Date: 14th January 2026
Our ref: MJT/tjc/050744

Re: Representation in respect of the Sunnica Energy Farm on behalf of the Environment Agency

We are instructed by The Environment Agency who we act on behalf of to make a representation regarding the Sunnica Energy Farm in respect of the non-material change to The Sunnica Energy Farm Order 2024 (SI 2024/802) and the proposed scheme as a whole.

Drawing Title
**FIGURE 10-14E
LANDSCAPE MASTERPLAN
SUNNICA WEST SITE B**

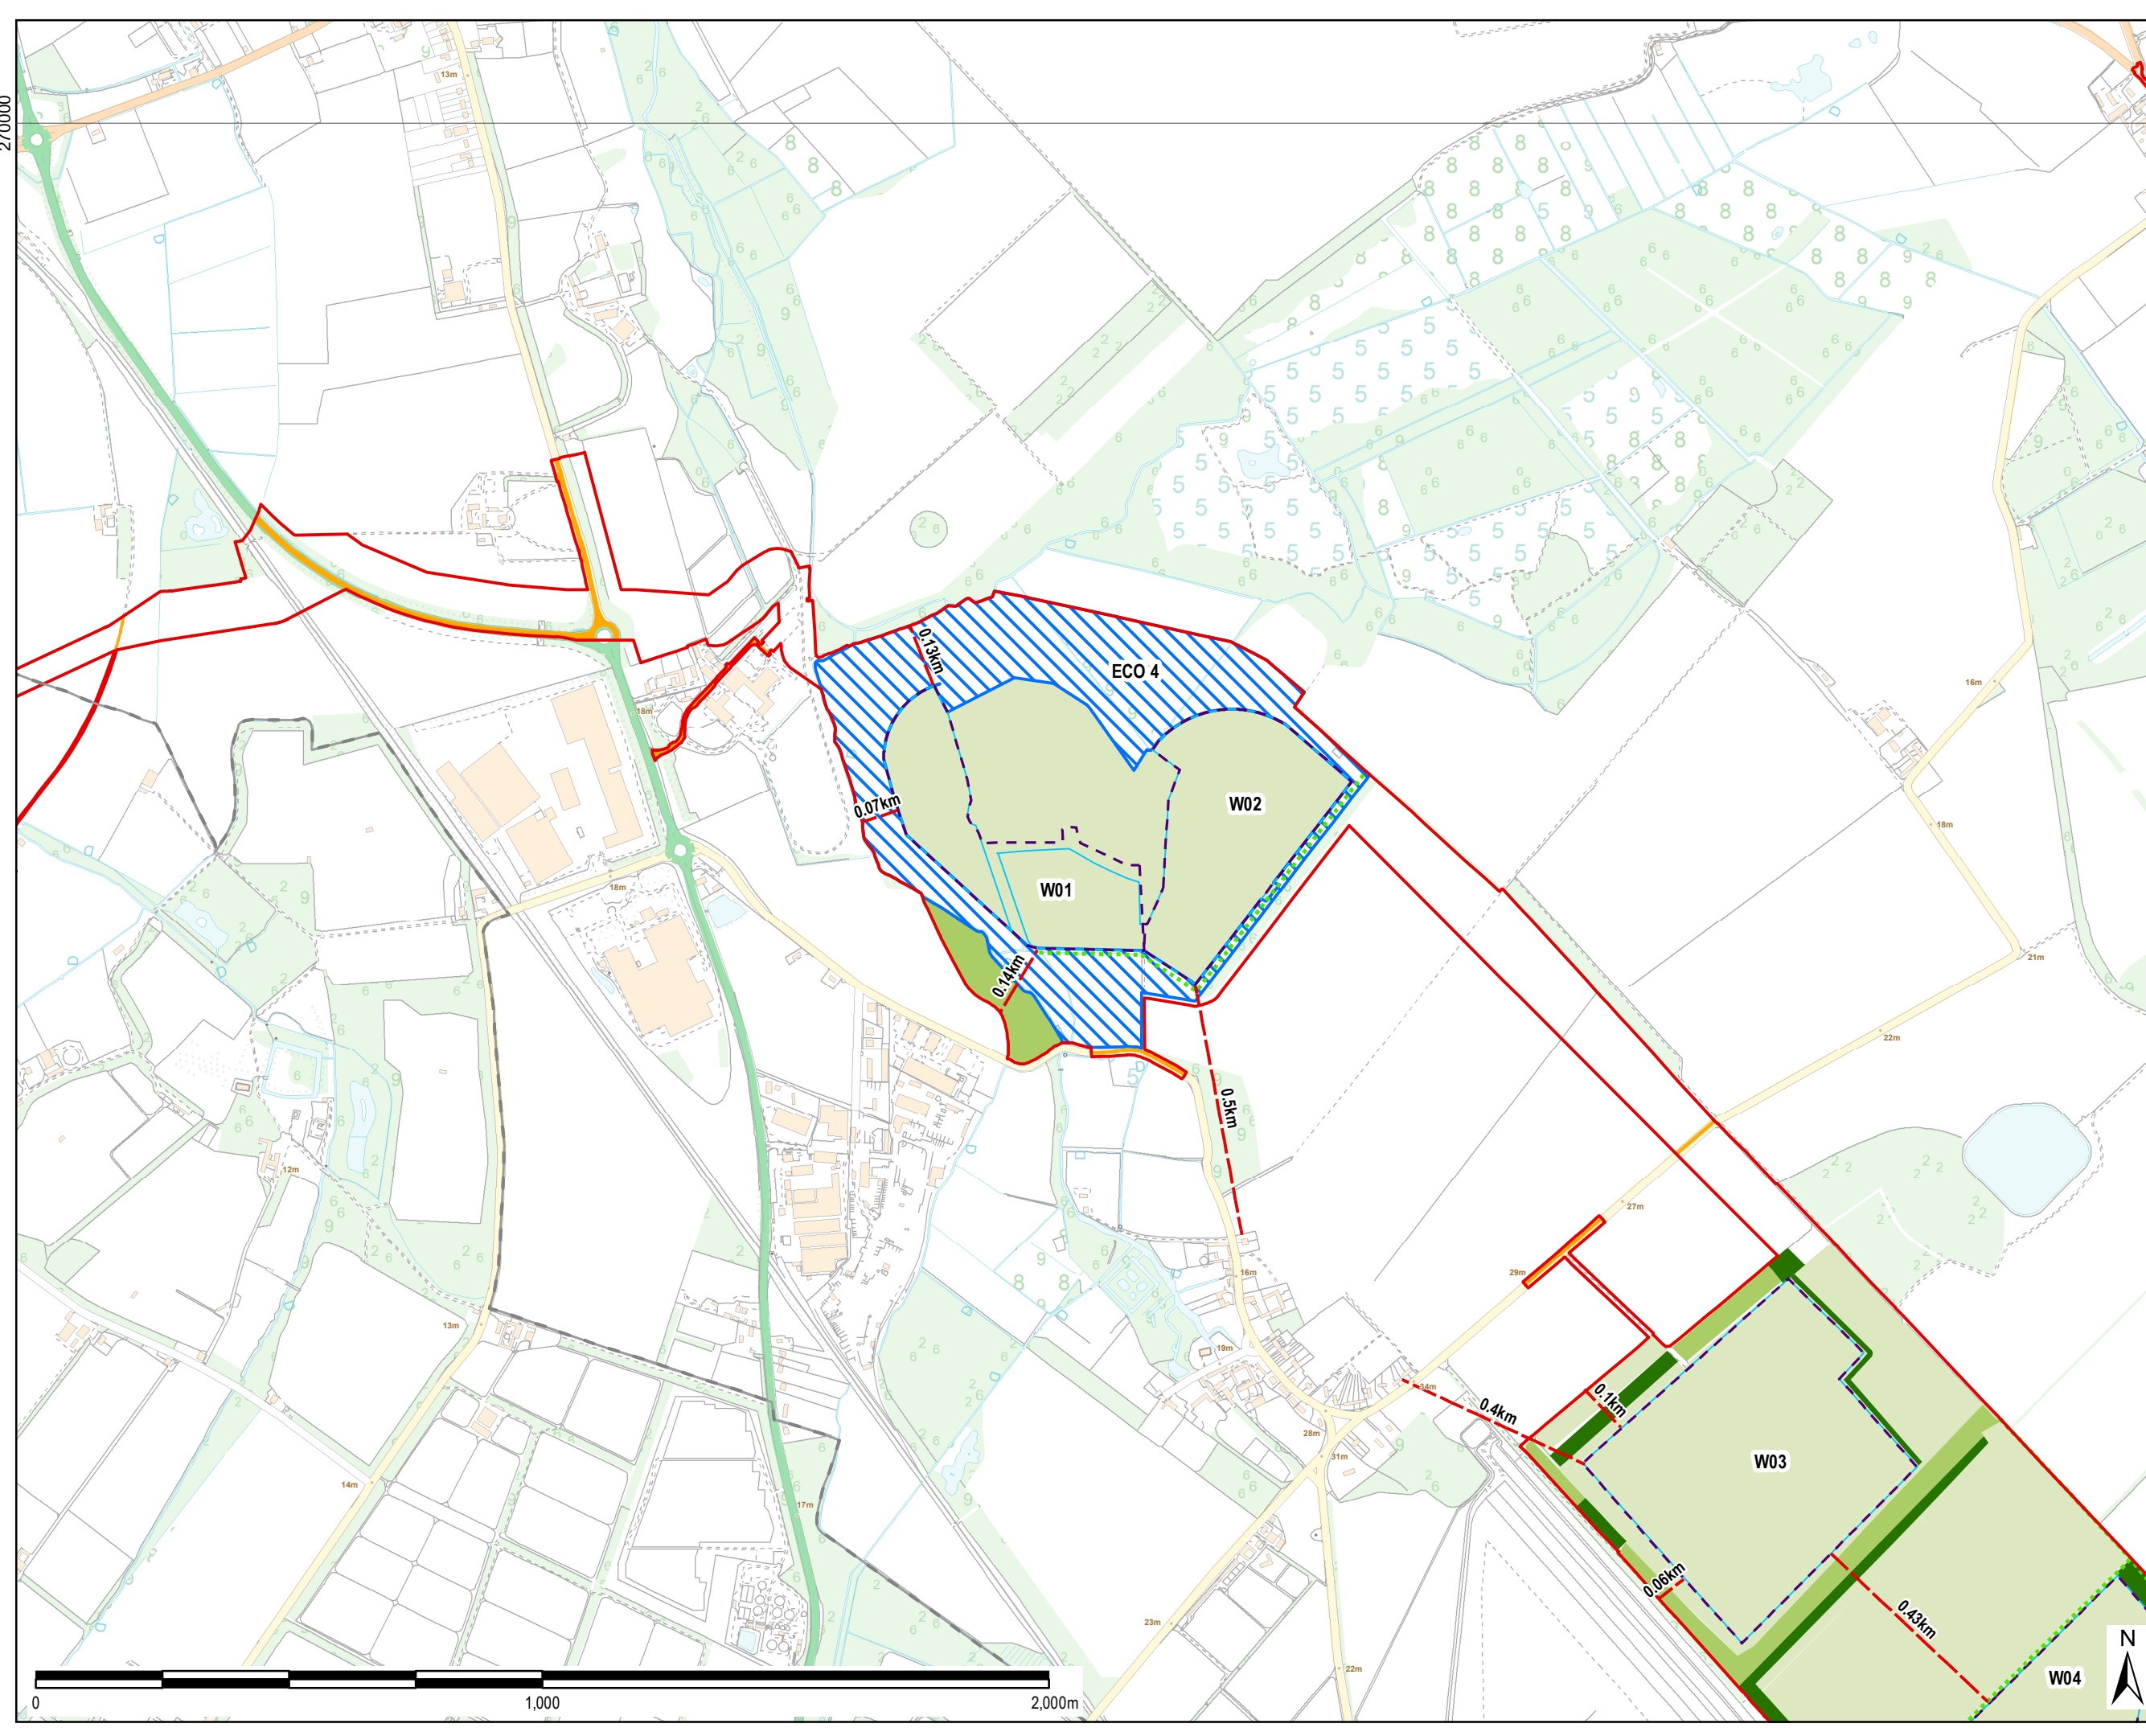
The Lodes Granta pipeline is a 10inch water pipeline as shown on the accompanying plans. Within the current proposals it would appear that a large section of planting (assumed tree planting) is proposed over the current route of the pipeline. In order to protect the pipeline and allow the ability for future maintenance and replacement of the pipeline, if necessary, a strip of land with a width of 5 metres over the pipeline should be excluded from the current tree planting proposals. The proposed planting as understood from the latest plans provided could compromise the existing pipeline as well as restricting future maintenance and replacement.

I trust the above is helpful when considering the latest amendment to the Sunnica Energy Farm Order 2024 as well as the overall design of the scheme. I would be grateful if the considerations regarding the proposed planting could be considered by the Secretary of State for Energy and Net Zero and the necessary amendments made to the current scheme design.
